Preliminary Acceptance Punchlist
El Paso County – Department of Public Works - Stormwater Section

Project Name:	Upland Flats
EDARP Filing Number(s):	CON2159, SF2112
ESQCP Number:	ESQ2139
Attendees:	DPW SW: Joshua Augustenborg, Erica Rylander, Ben Jones DPW Development Services: Brad Walters Developer: Brett Lewis, Nate Leblanc
Date of Walk-Thru:	10/18/2023
Walk-Thru Number:	1

PROJECT NO. 098302009  
 SHEET C 301

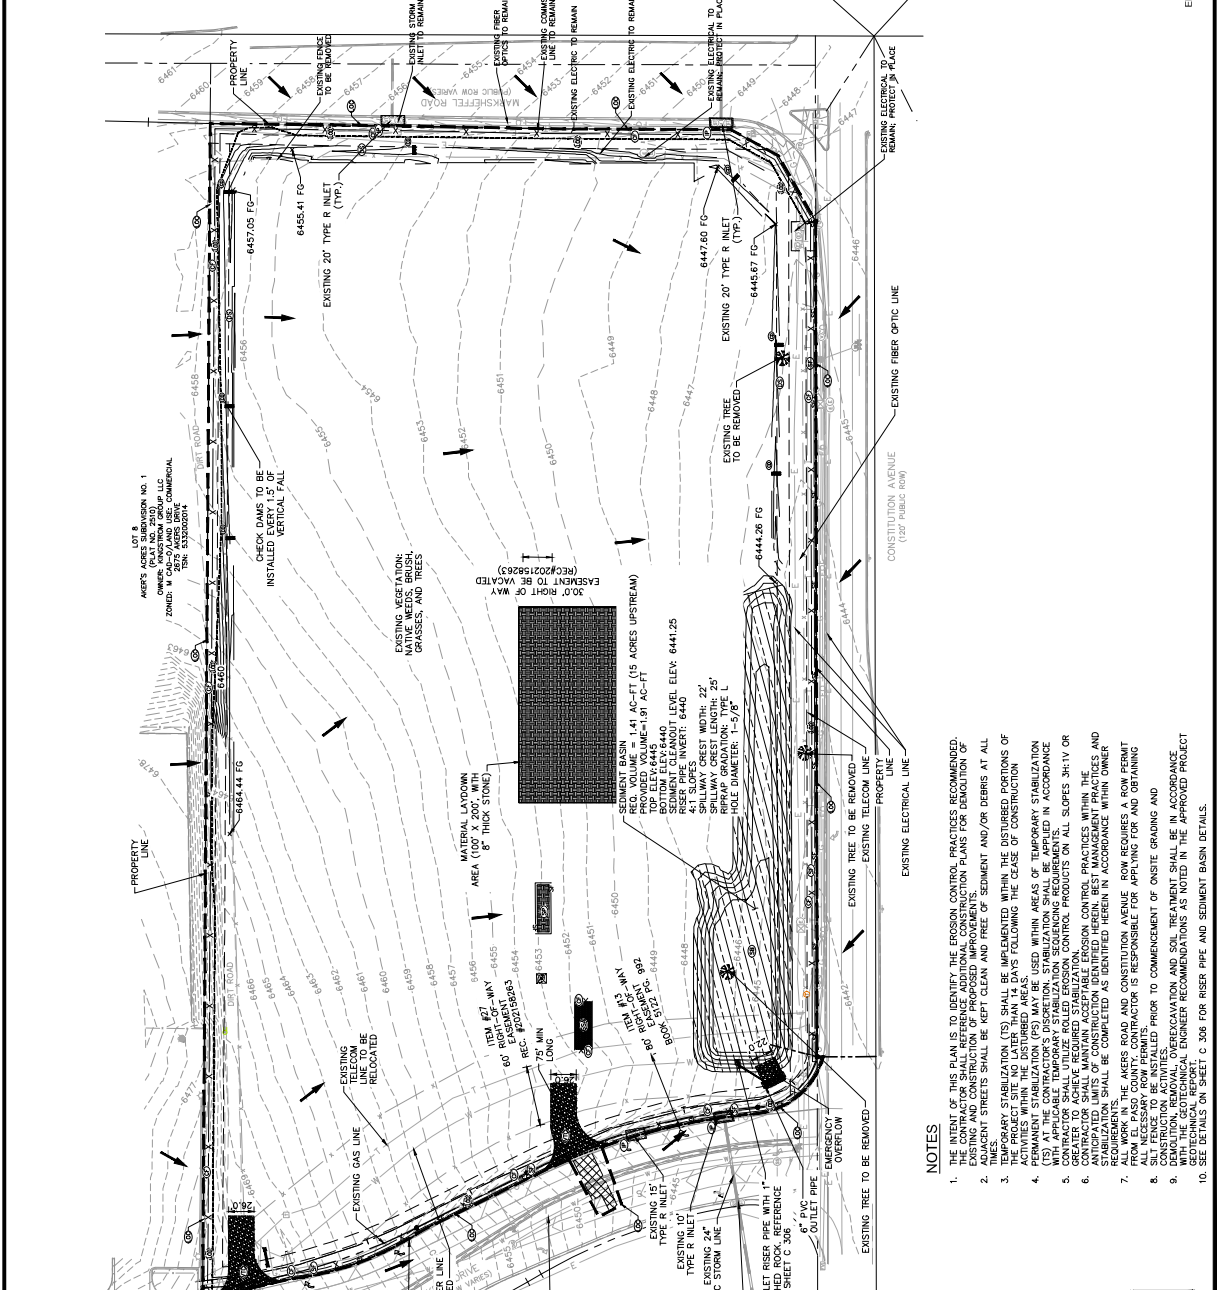
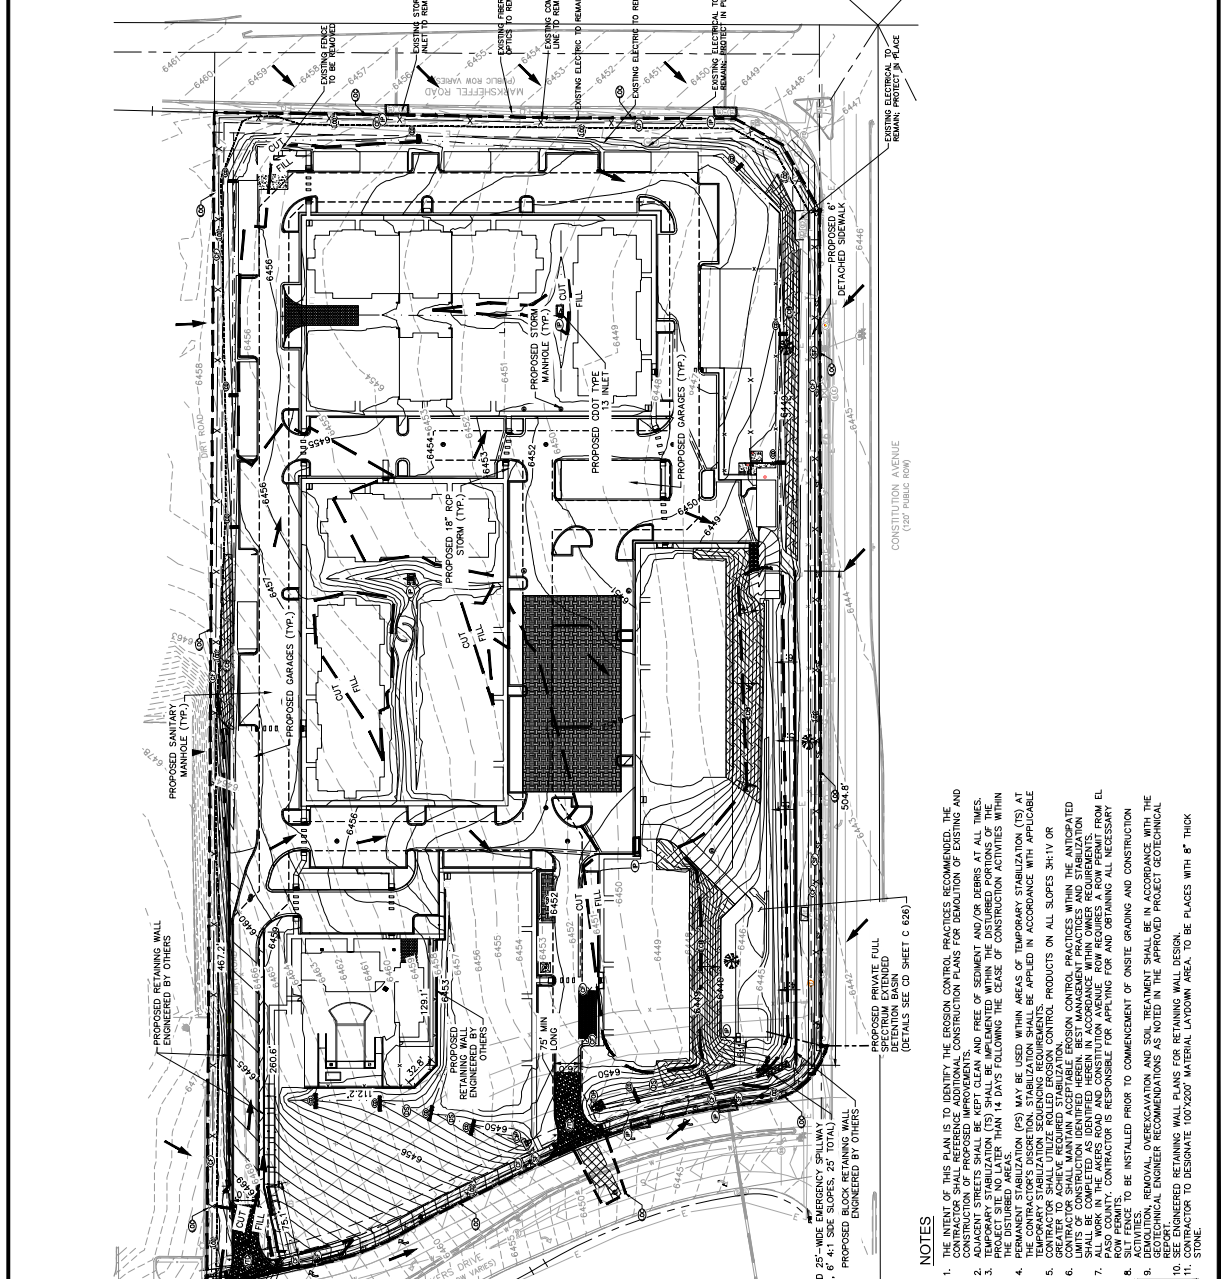
- Missing drainage swale south of dog park per approved plans. Reference Grading and Erosion Control Plan (GEC) Sheet C303. Reference Photo #7.
- Check dams along the south perimeter are installed in the wrong location. Plans call for installation of check dams in swale at top of slope. Reference GEC Sheet C303. Reference Photo #6.
- Curb cut on north side of garages, east of Building 6, was not installed per approved plan. Ensure stormwater flows from the north swale and east swale to Extended Detention Basin to meet water quality treatment requirements.
- The swale at southwest corner of site appears to be lower than emergency spillway. Verify elevation.
- Fine-grade swale at southwest corner of site for positive drainage.

Photo 6: South side Limits of Construction (LOC) check dams are installed at bottom of slope. Plans call for Installation at top of slope. Reference GEC sheet C 303.

Photo 7: Missing drainage swale south of dog park per approved plans. Reference GEC sheet C 303.
